About the application

Application number: 2023/93753	
What is the application for?:	Alterations and extension to outbuilding to create dwelling forming ancillary an
Address of the site or building:	371, Halifax Road, Hightown, Liversedge, WF15 8DU
Postcode:	WF15 8DU

Client		Mr & Mrs Pitman	
Job		371 Halifax Road Liversedge	
Title		Proposed Side Elevations	
Drawn By	RK	Date	Nov 2023
Eng. Check		Scale	1:100
Tech. Check			
Drawing No.		Rev.	
2023 / 436 / 04

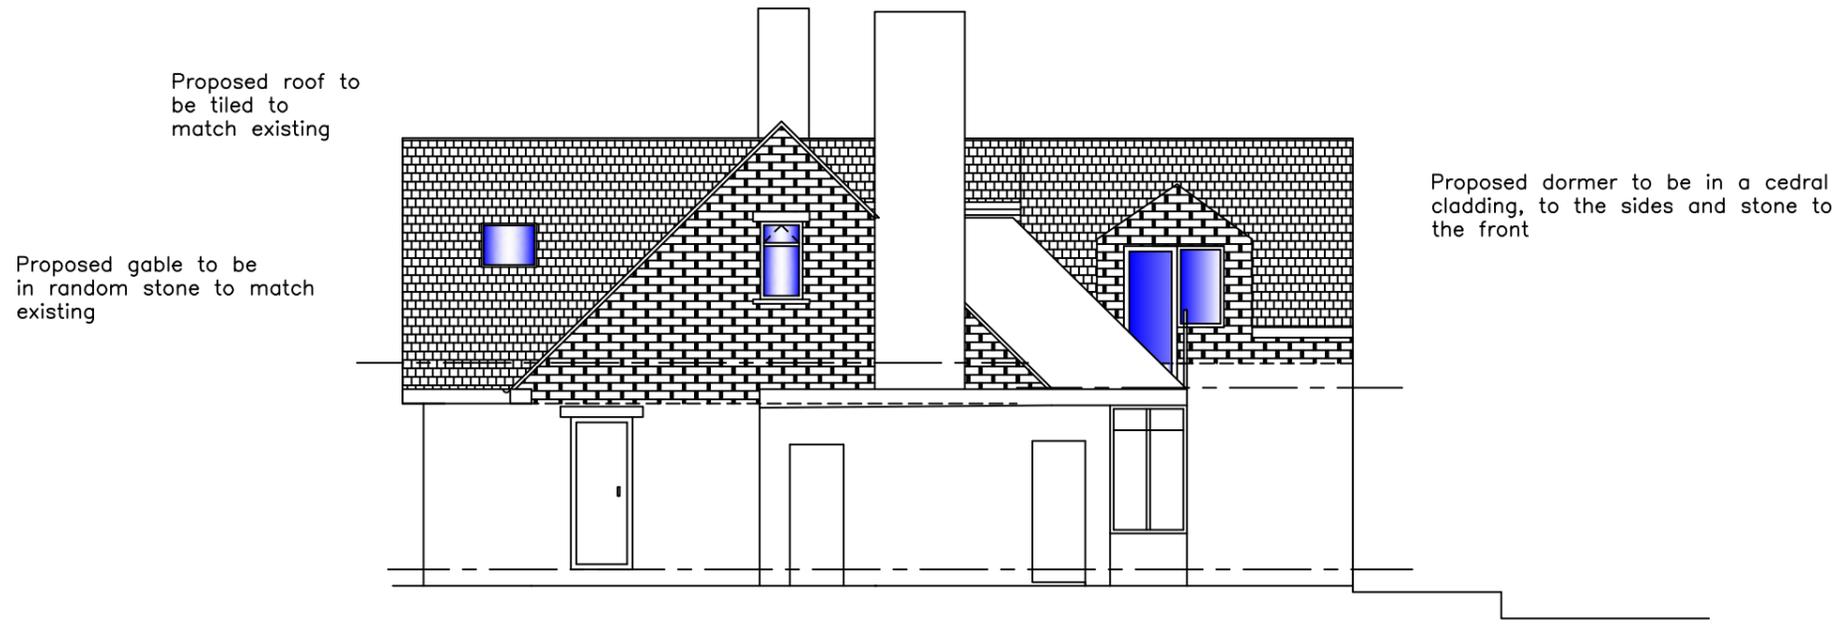
Type of comment: An objection	
Do you wish your comments to be published on the website anonymously?	Yes
<p>Dear Sir/Madam.</p> <p>Application No 2023/93753</p> <p>Having reviewed the proposed planning application to 371 Halifax Road, Liversedge, we wish to object on the following grounds:</p> <p>(1)Side window(s) with a view directly</p> <p>(2)Close proximity of the proposed annexed building to boundary</p> <p>(3) privacy affected due to the proposed first floor balcony</p> <p>We would also like to add that the previous owner of had applied and was refused planning permission previously to add buildings in the garden as the site is located within the designated green belt, as set out in the national planning policy framework, chapter 9 (planning reference number 2015/60/92941/E).</p> <p>Kind regards.</p>
